**To:** FILE  
**From:** Jean Fraser  
**Subject:** Application ID: 2015-085  
**Date:** 6/26/2015

To: Jean Fraser  
Barbara Barhydt  
From: David Margolis-Pineo  
Re: 81 Industrial Way – New Office Complex (2015-085)

PRECAST MANHOLE

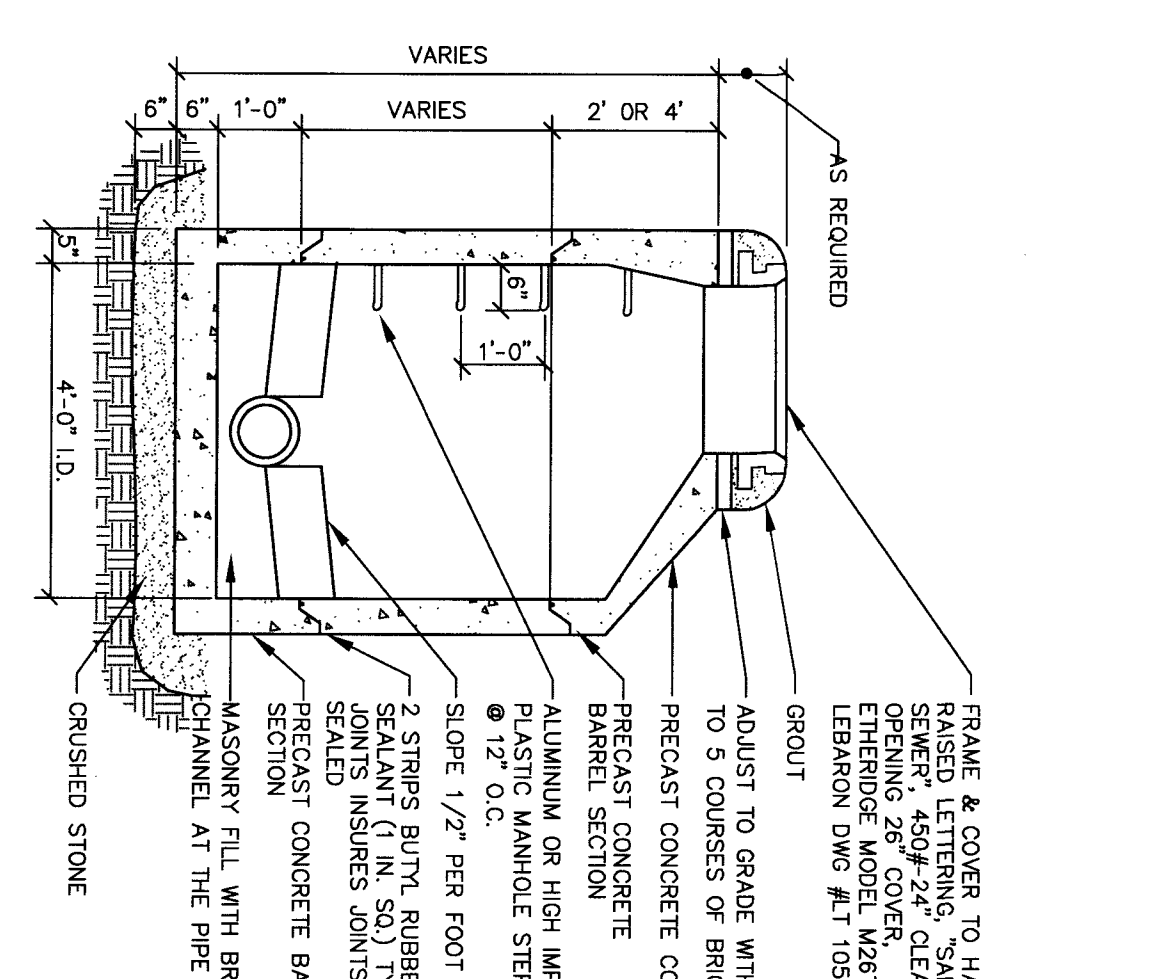
1. All plans require a professional stamp.
2. Please add note stating that all work within the road right of way shall meet City of Portland Technical Manual standards.
3. Provide detail of 6" sewer connection in Industrial Way showing manhole penetration, and shelf and channel configuration.
4. It appears that radius granite curbing is proposed for the drive cut consistent with the other drive cuts in this park. Please verify that in fact that is the intent.
5. This Department is supportive of a waiver for sidewalks and granite curbing along Industrial Way. However a midblock pedestrian crossing of Industrial Way is being discussed and may be a recommendation.
